Erection of single storey detached double garage
Harcourt West Drive Angmering

Thank you for your internet representation made on 13th December 2017 which has been recorded as '**an objection**' with the comments as follows:

DRAWING	PROPOSED SITE PLAN AND ELEVATIONS																						
Date	October 2017	Drawn By	PJC																				
Scale	1: 200 - 100 @A3	Iss. App. By	DKC

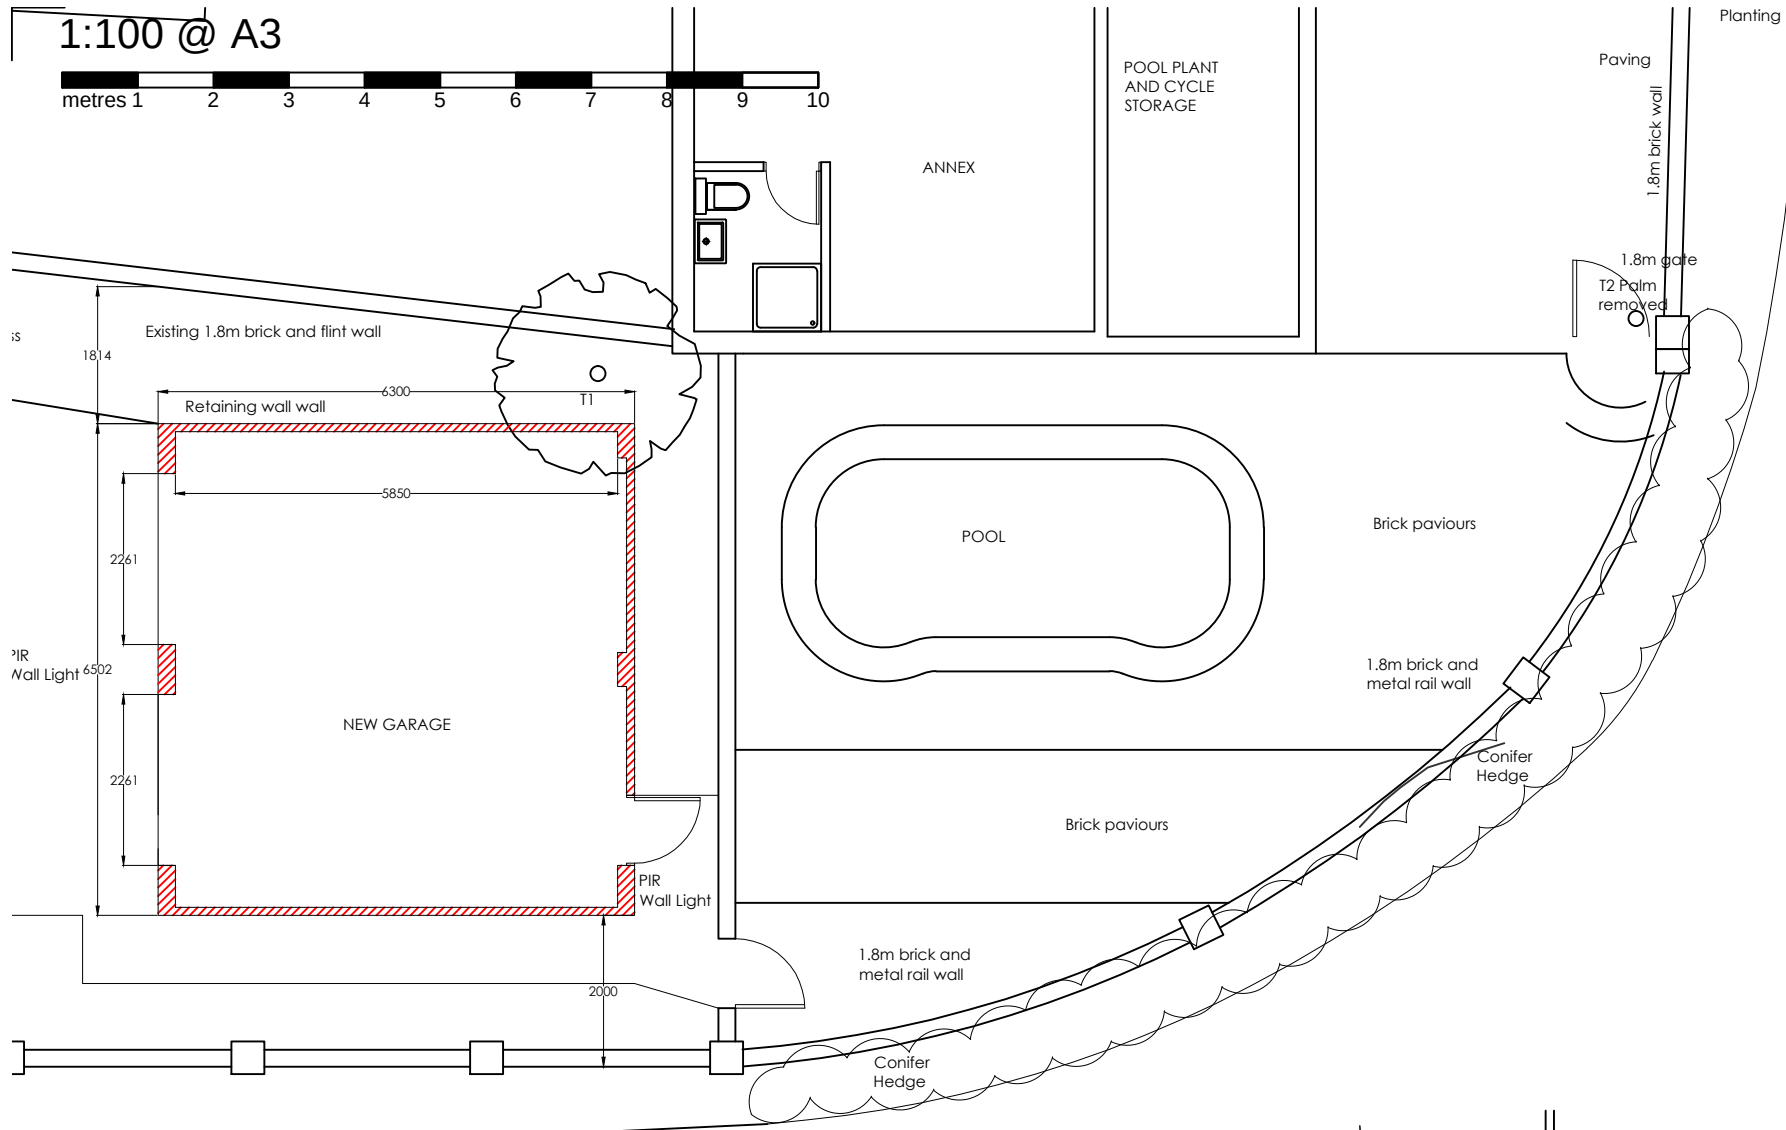
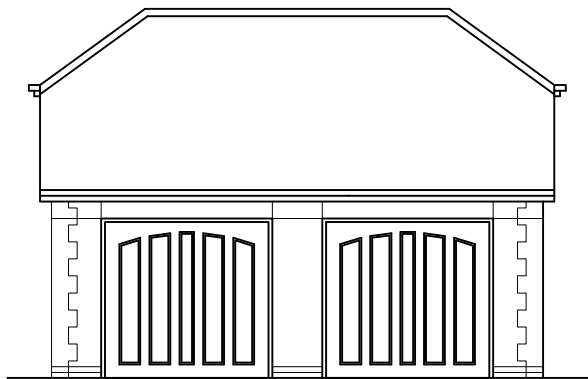
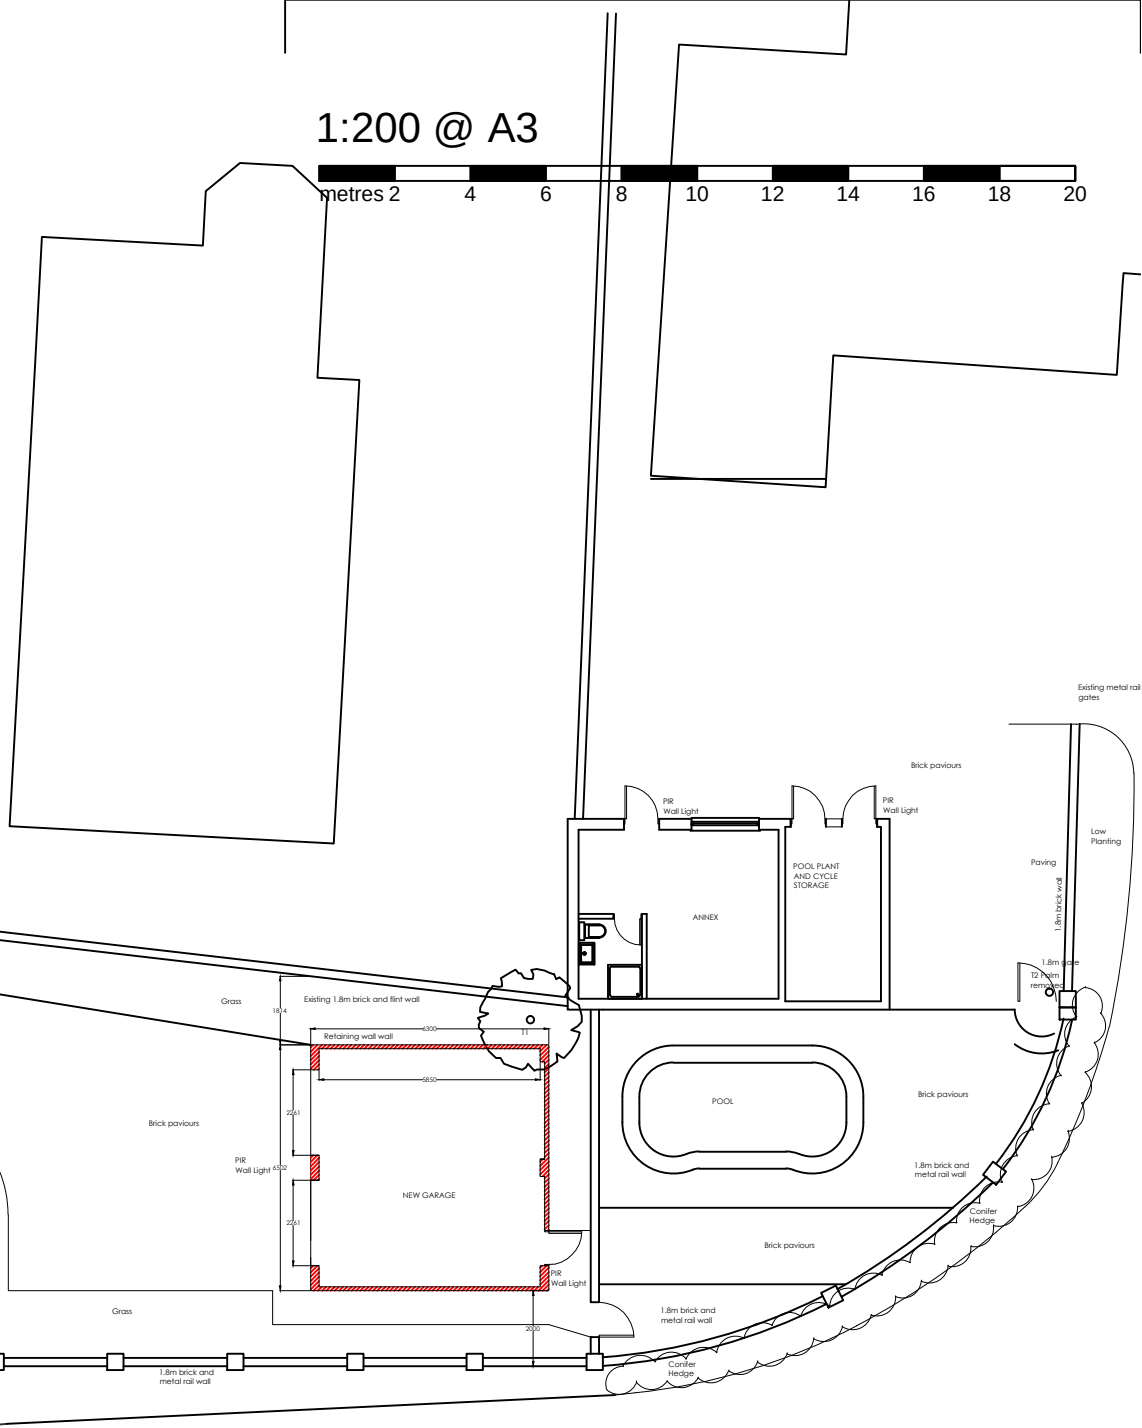
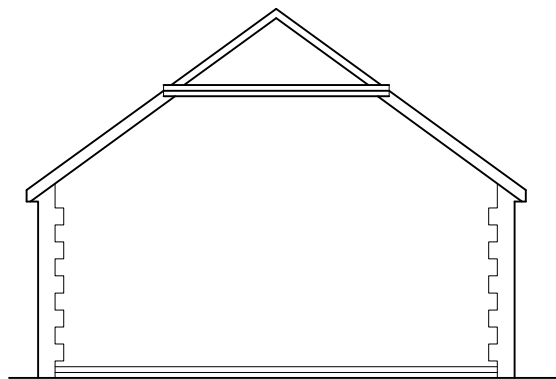
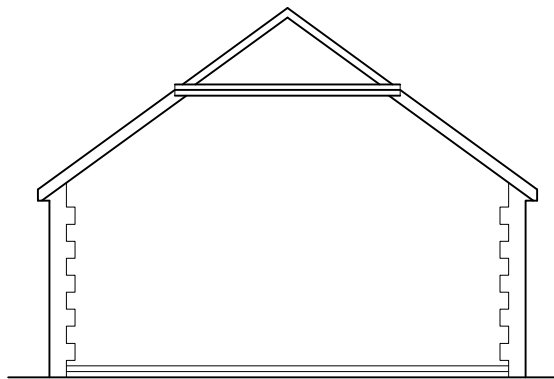
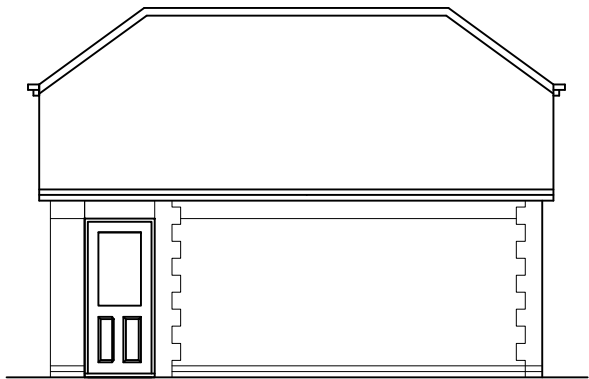
The report given by the Architect includes inaccuracies. There is a well documented history of flooding on this corner, which will be made worse with the loss of the garden into hard surfaces. Already having to cope with 2 new driveways and no new drainage for run off down the 2 meter slope.

There is now very well used public footpath running opposite the proposed new driveway. This usage has been added to considerably since the advent of Out of Bounds/Lanes Health and Golf facilities, with more to come. It will be very, very dangerous, especially children.

The corner already presents as a blind corner, with an accident waiting to happen with extra direct car access so close. The present pedestrian standing creates a safe point.

The size and height will totally overpower the existing views and outlook for all neighbors.

<table><tr><td>PROJECT</td><td colspan="3">HARCOURT West Drive. Angmering. Littlehampton BN16 4JE</td></tr><tr><td>DRAWING</td><td colspan="3">SITE LOCATION AND BLOCK PLANS</td></tr></table>

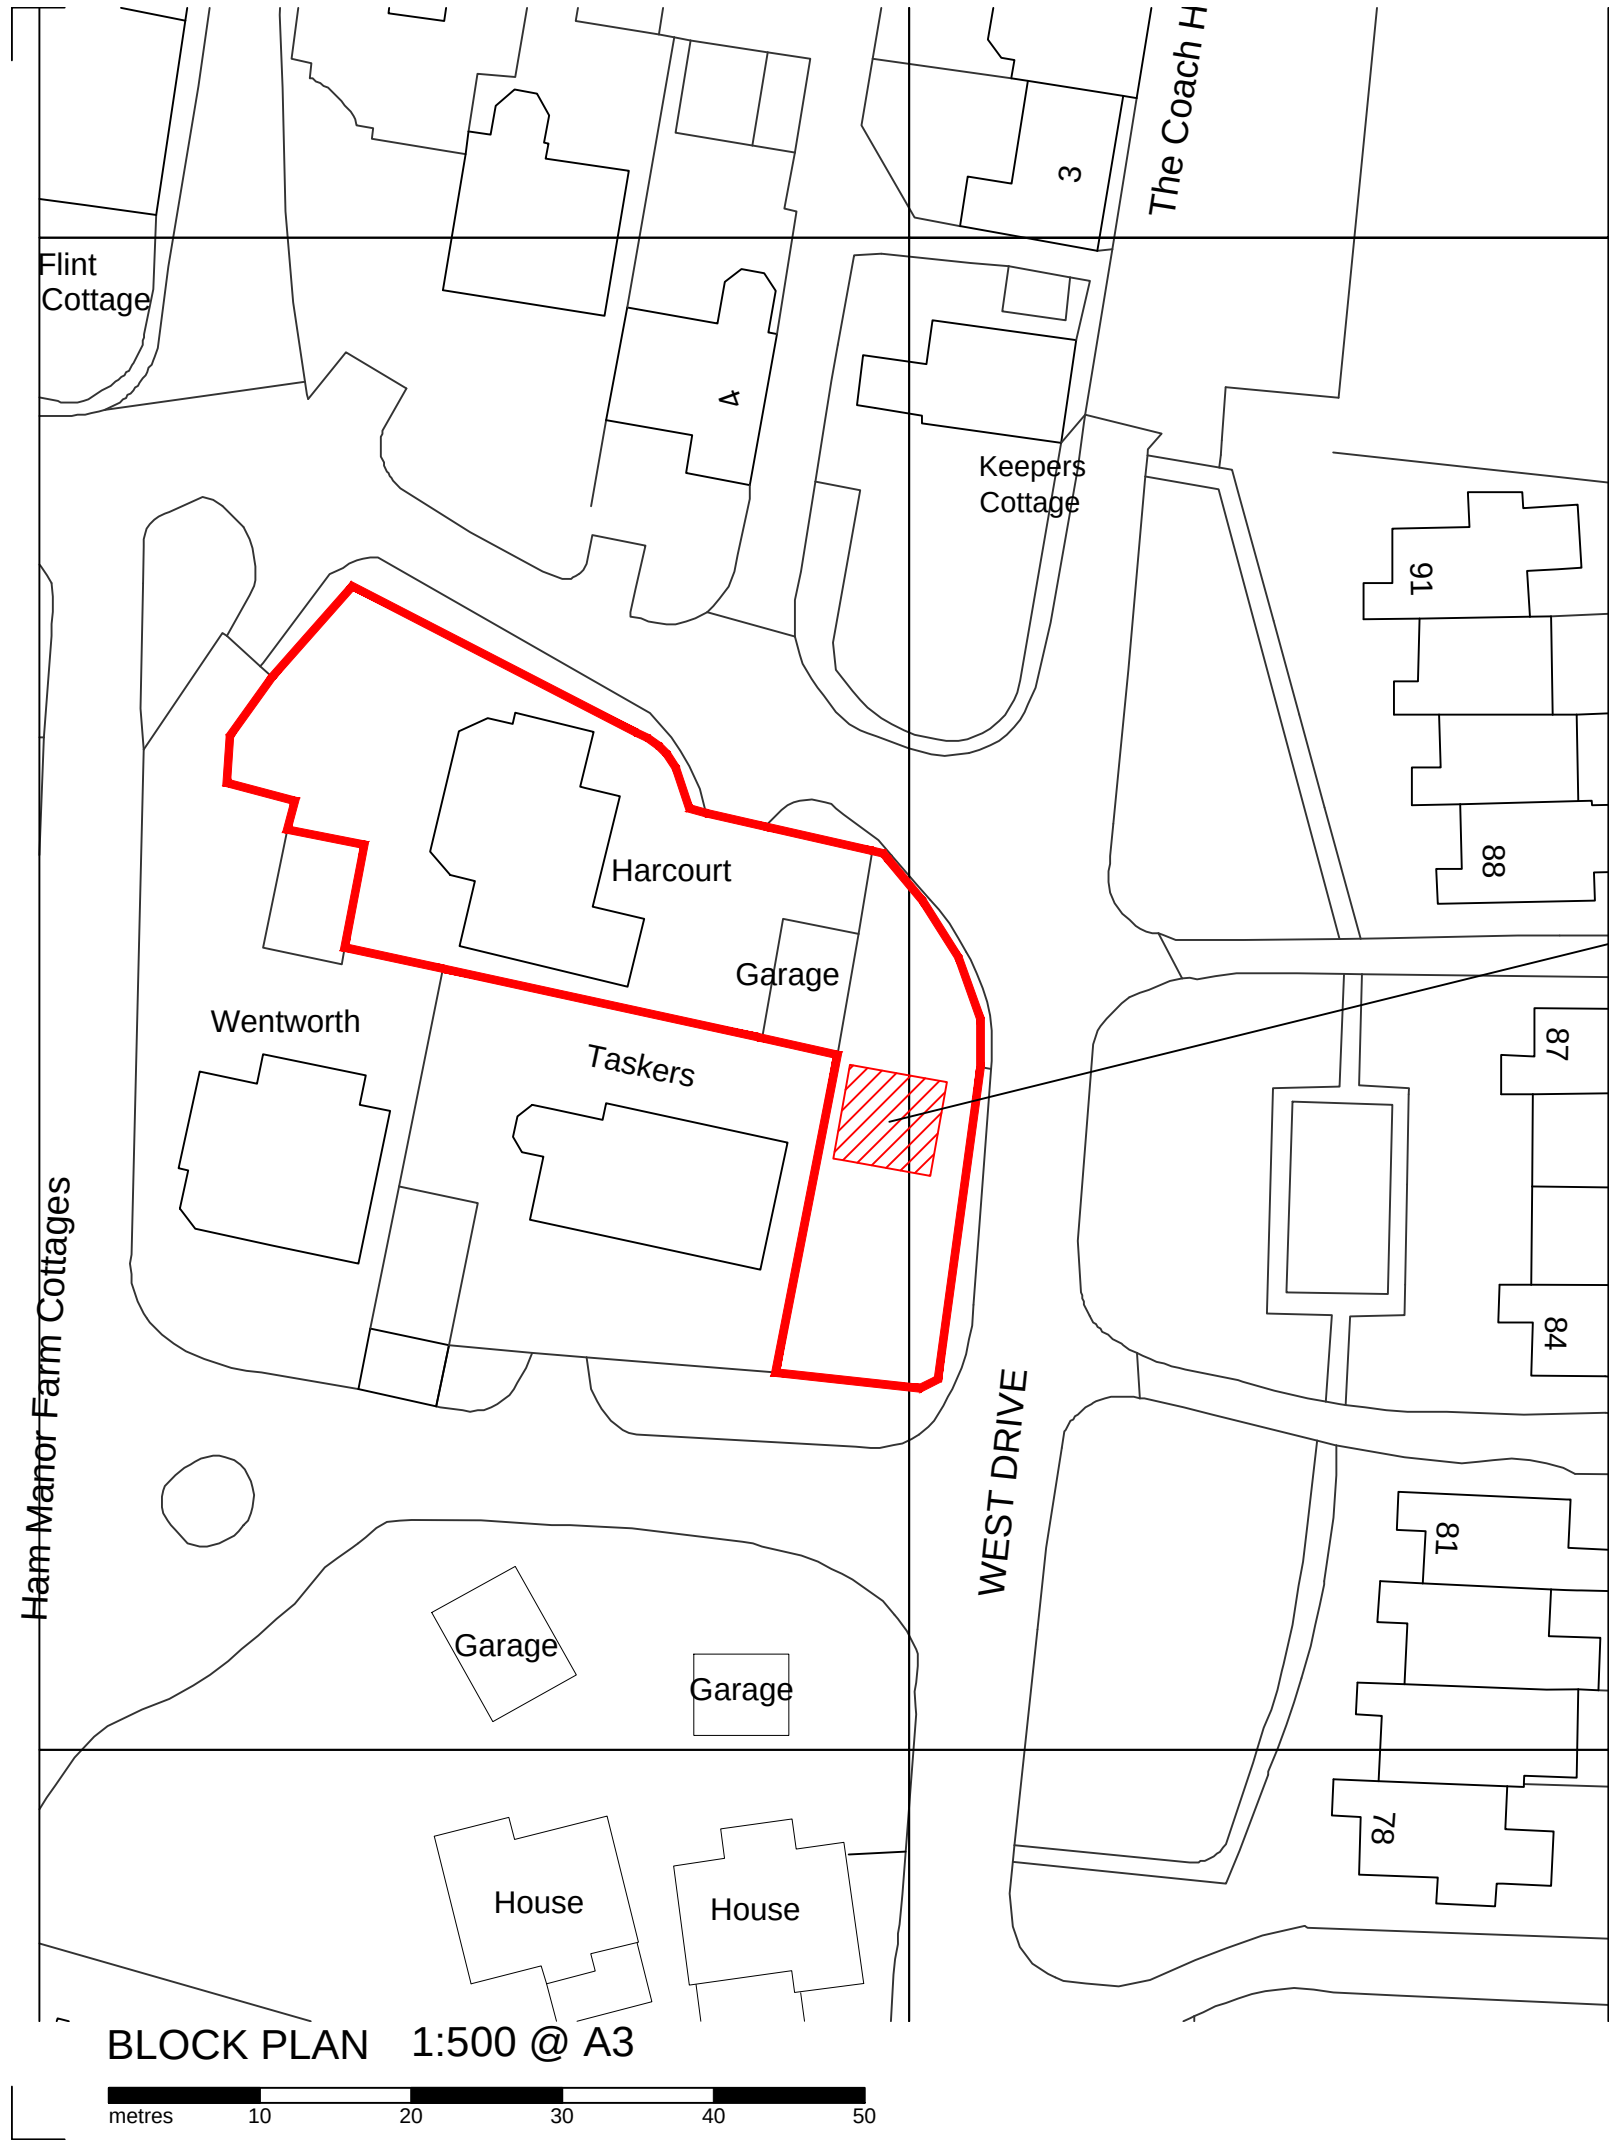
The property already has space for 4/5 car parking, plus permission for one more garage. There are already garages turned into accommodation on site, but inaccuracy as marked on map provided as Garage.
